Application no: H17/0006/99

Description: Alterations & extensions &
conversion of outbuildings
to form single dwelling.

Location: Coney Garth Lane
Surfleet
Spalding
Lincolnshire

Amendment: Alterations to chimney stack, alter window to lounge/
landing, amend roof to entrance hall. Dwg. No. 99/01/01A

Scale 1:50/1:100	Drg. no.
Date Jan. 99	99/01/01A

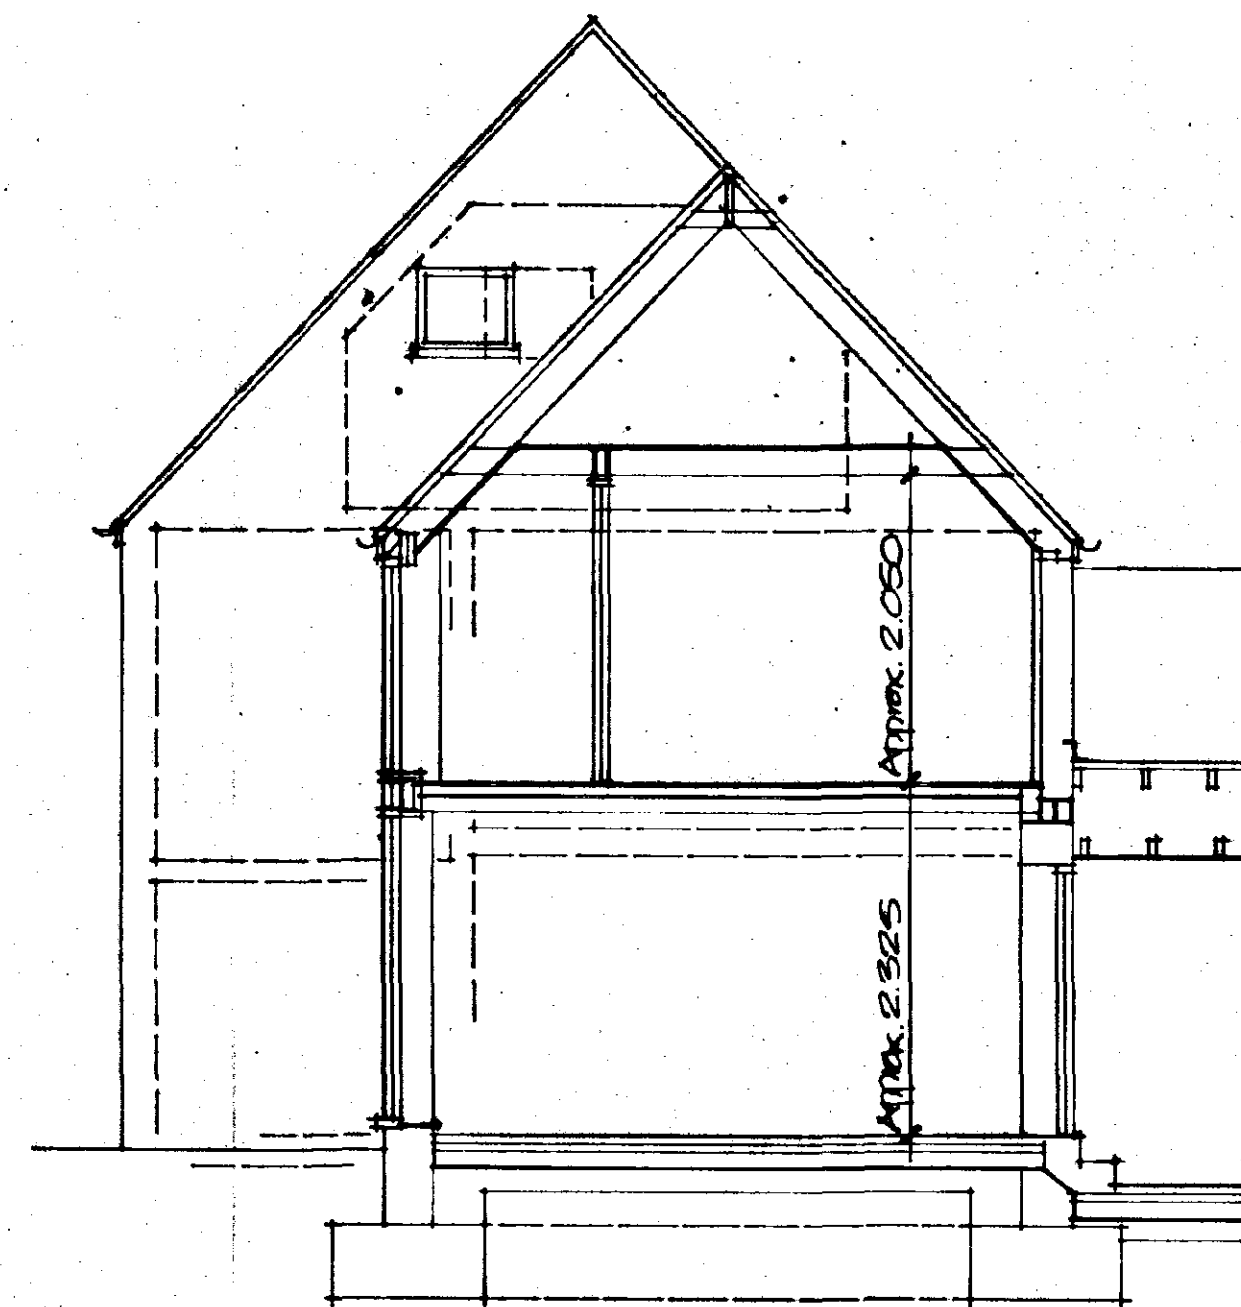
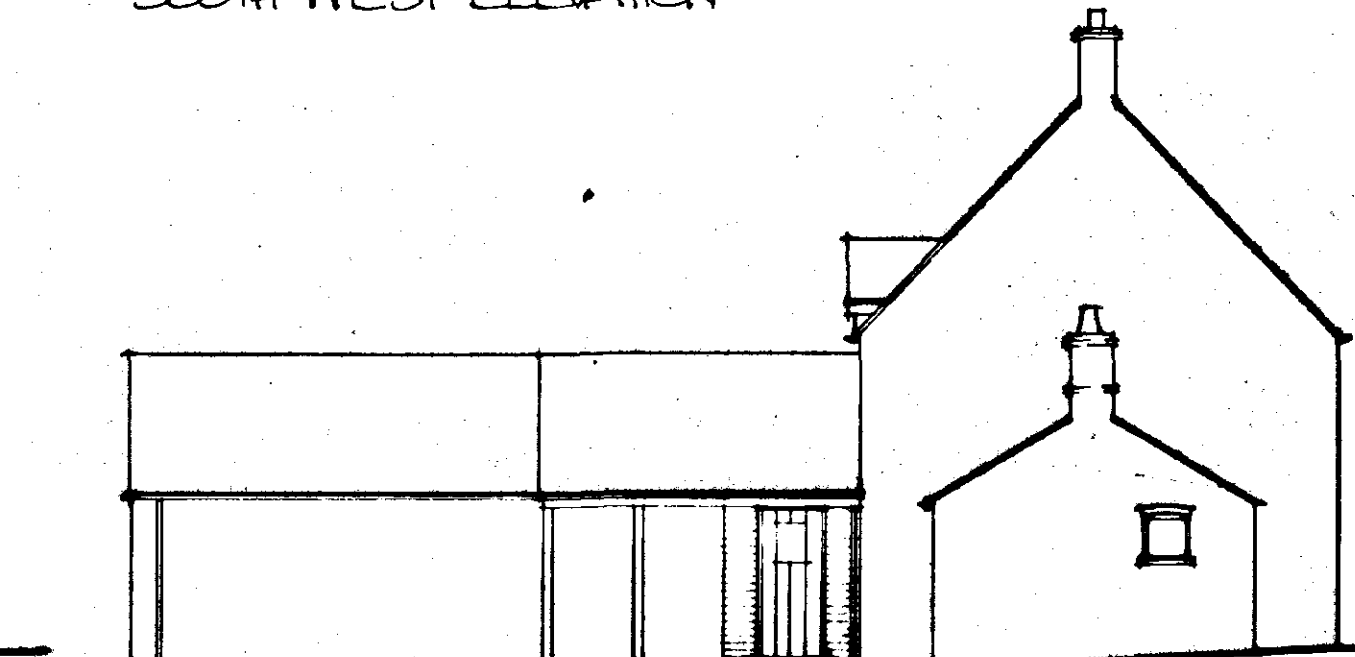
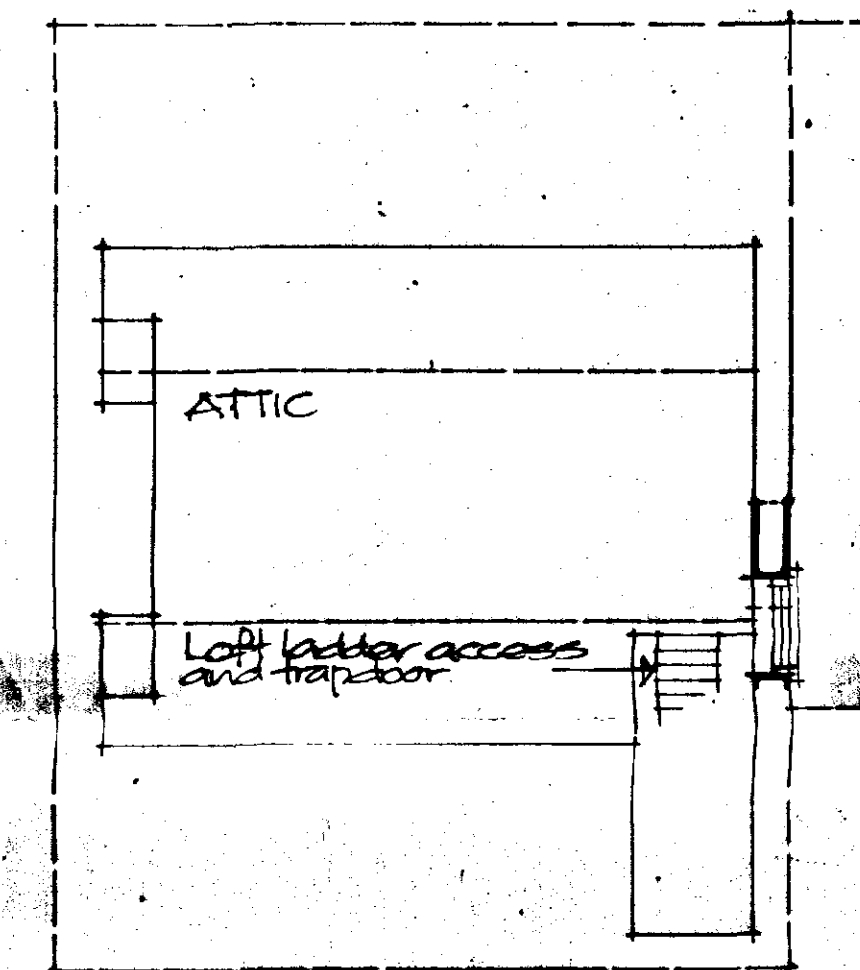
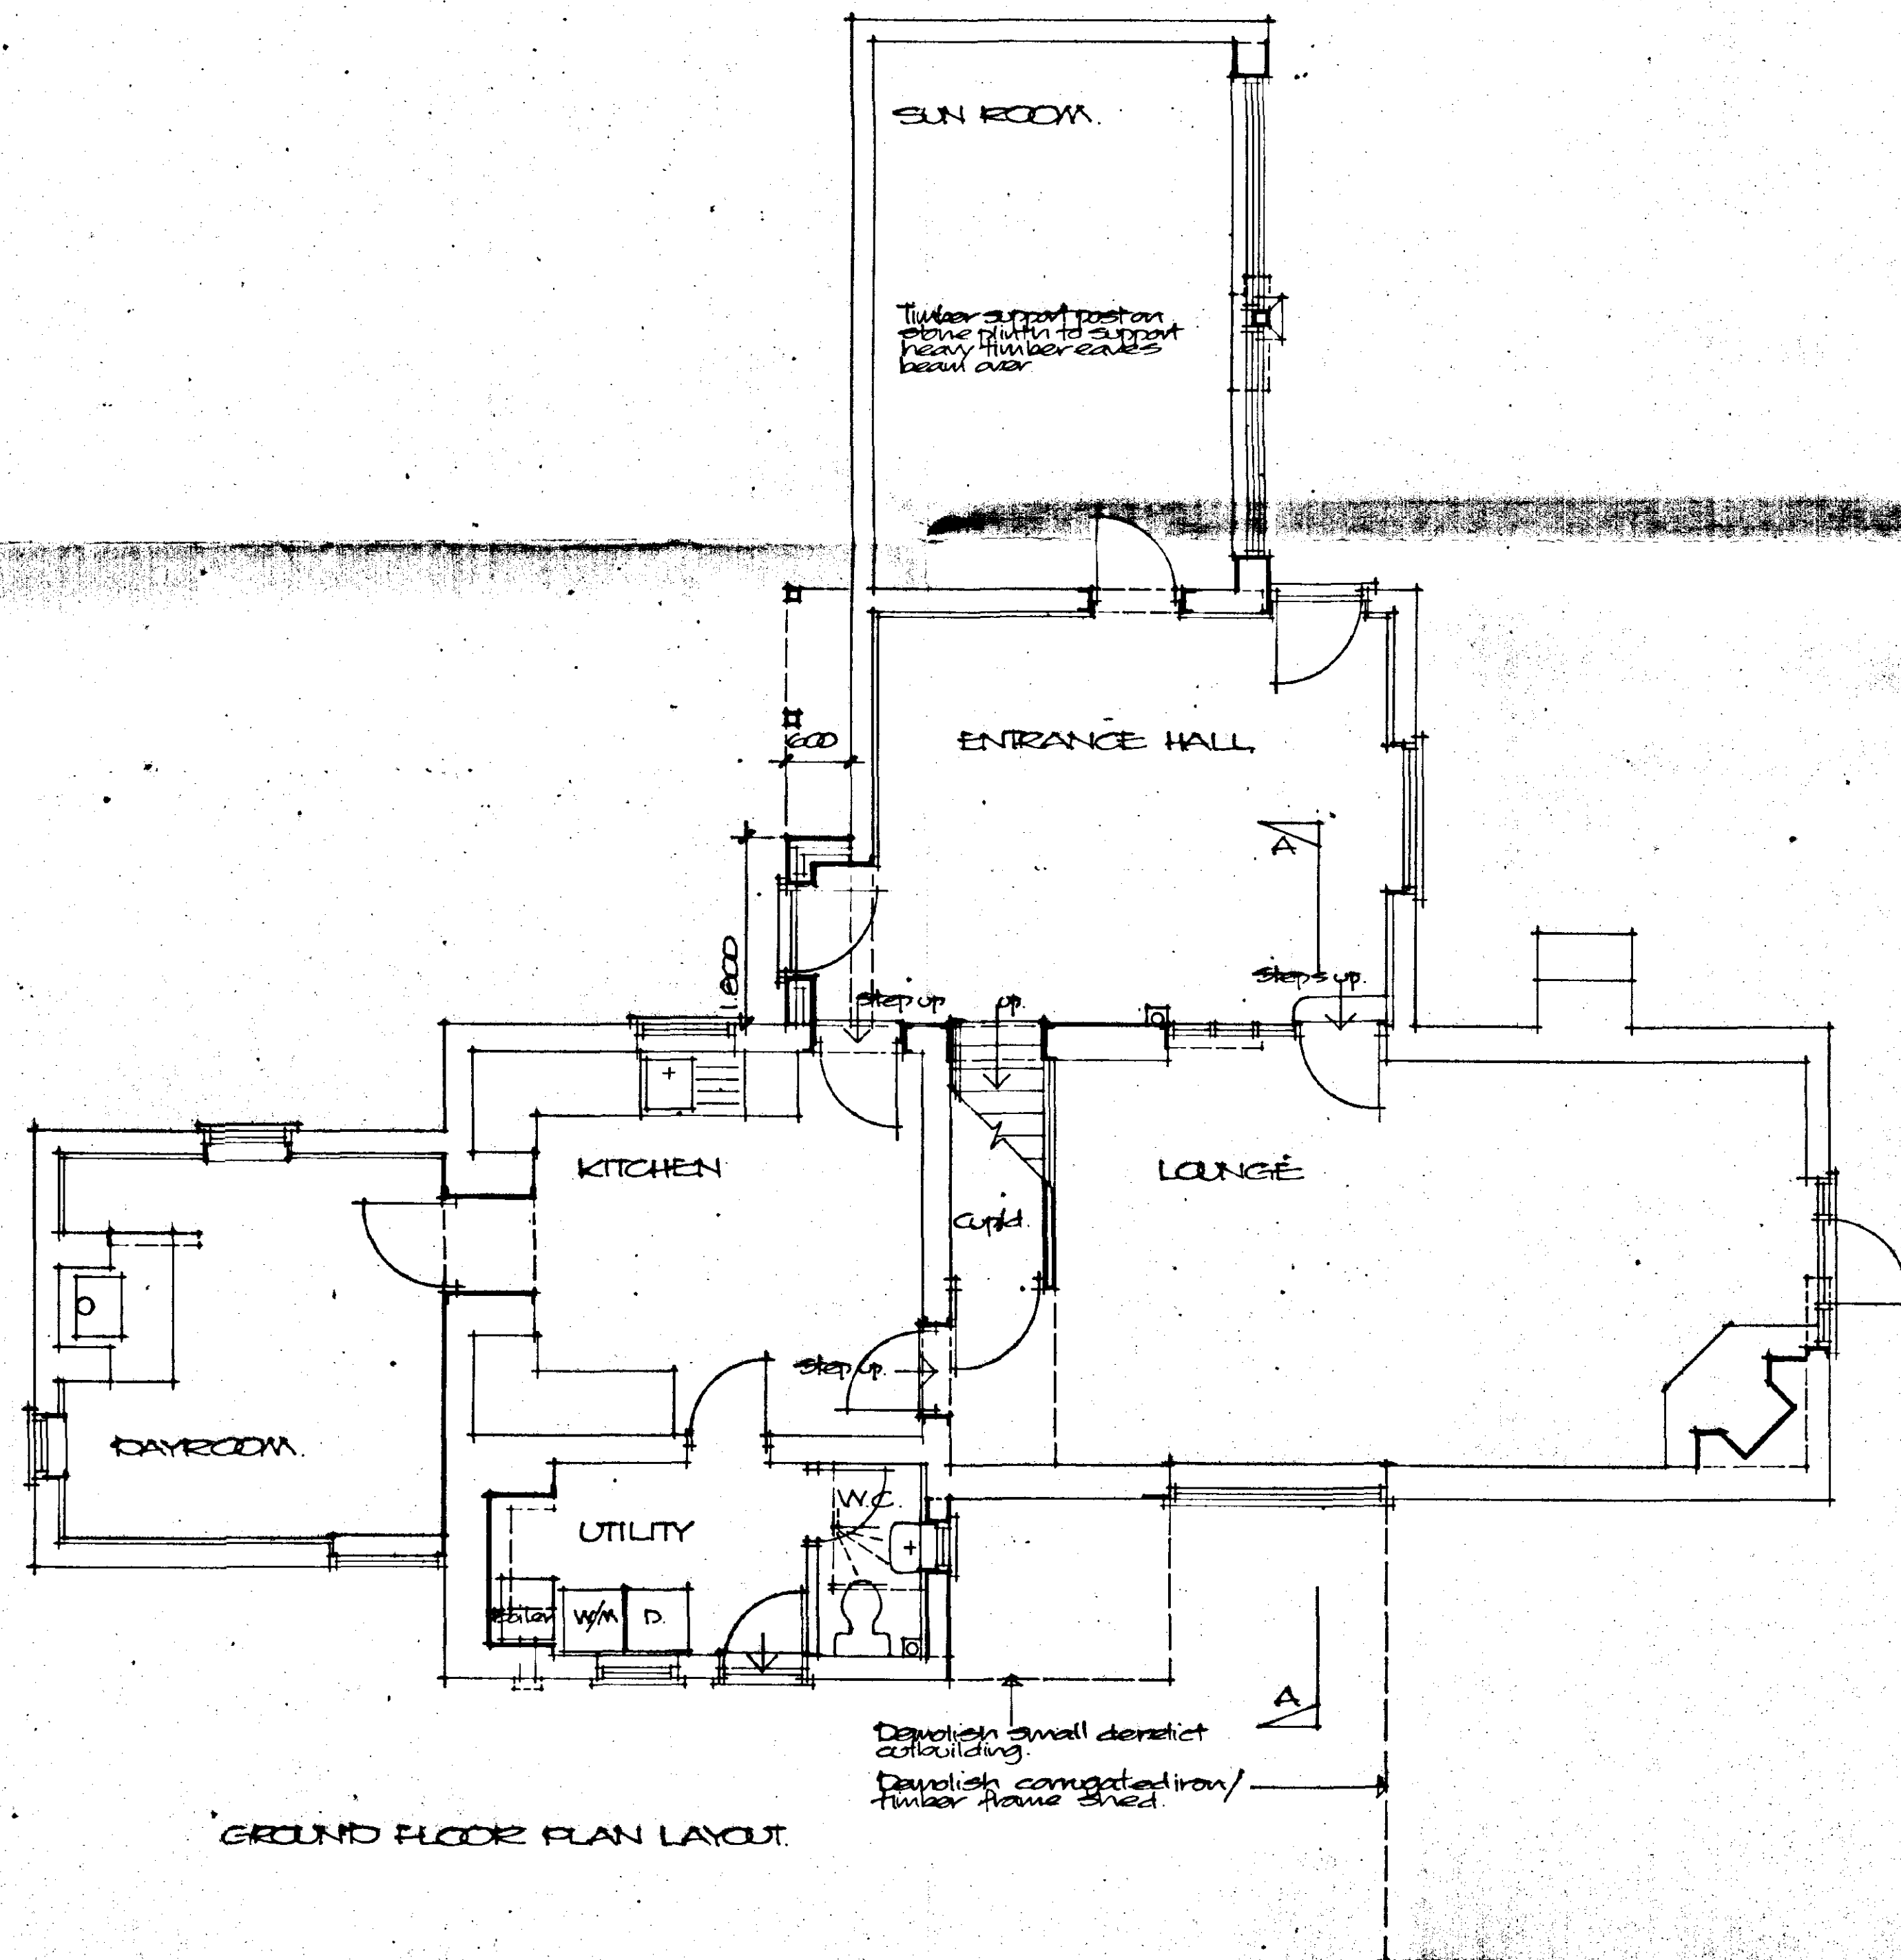
1. CHIMNEY STACK TO LOUNGE ALTERED.
2. WINDOW TO LOUNGE / LANDING ALTERED.
3. DOOR TO ENTRANCE HALL ALTERED.
AND TYPE OF DOOR TO OUTSIDE.
